2.36/37: A508 modelling as a bypass route for the M1 during closures.

2.38: Inclusion of committed development and growth in traffic modelling.

2.41: Validity of the modelling and effectiveness of the weight restrictions.

2.53/54: Noise measurements taken by SRNG in WR for Deadline 1 (REP1-054).

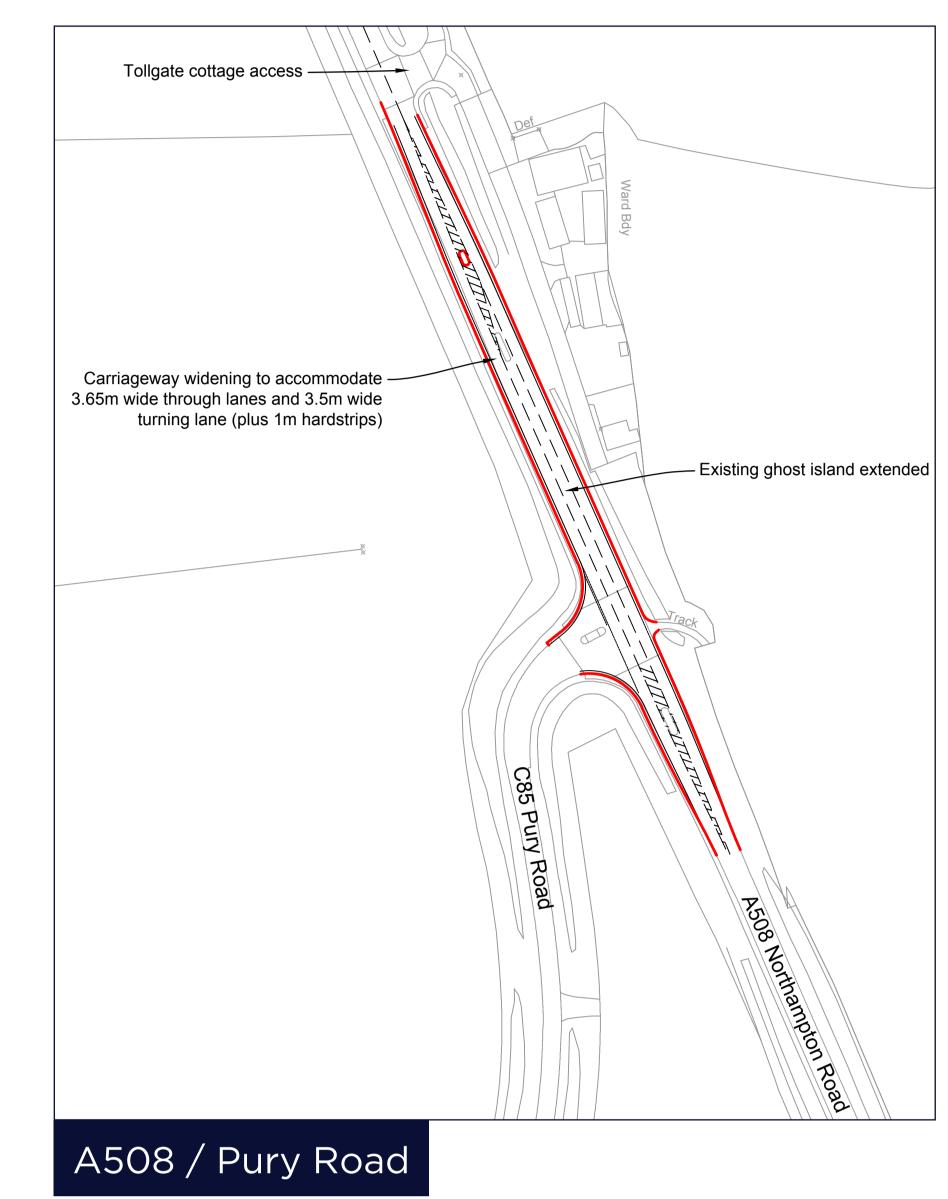
We are very concerned that the severe hazards presented by the S-bends on the A508, in which Woodley's Farm Day Nursery is situated, have not been recognised and proposals made to eliminate them. SRN's WR Pt B para 7.8 and response to Applicant's Doc 8.9 Responses to Other Parties' Deadline 2 Submissions (PINS doc TR50006-000983) and matters raised at ISH2 and others refers. A further serious accident, requiring an air ambulance, has occurred on these bends since then, on 16th February 2019. The considerable volumes of traffic passing this point when M1 diversions are in operation heighten the dangers. The fact that 5 serious accidents have occurred in these S-bends since December 2017 (averaging 1 every 3 months) indicates that this needs revisiting. The potential for a serious accident to a child is significant.

NPSNN 4.66 requires the scheme to show that steps have been taken to minimise road casualty risks and to contribute to overall improvements in safety on the Strategic Road Network. This is clearly not the case on this section of the A508.
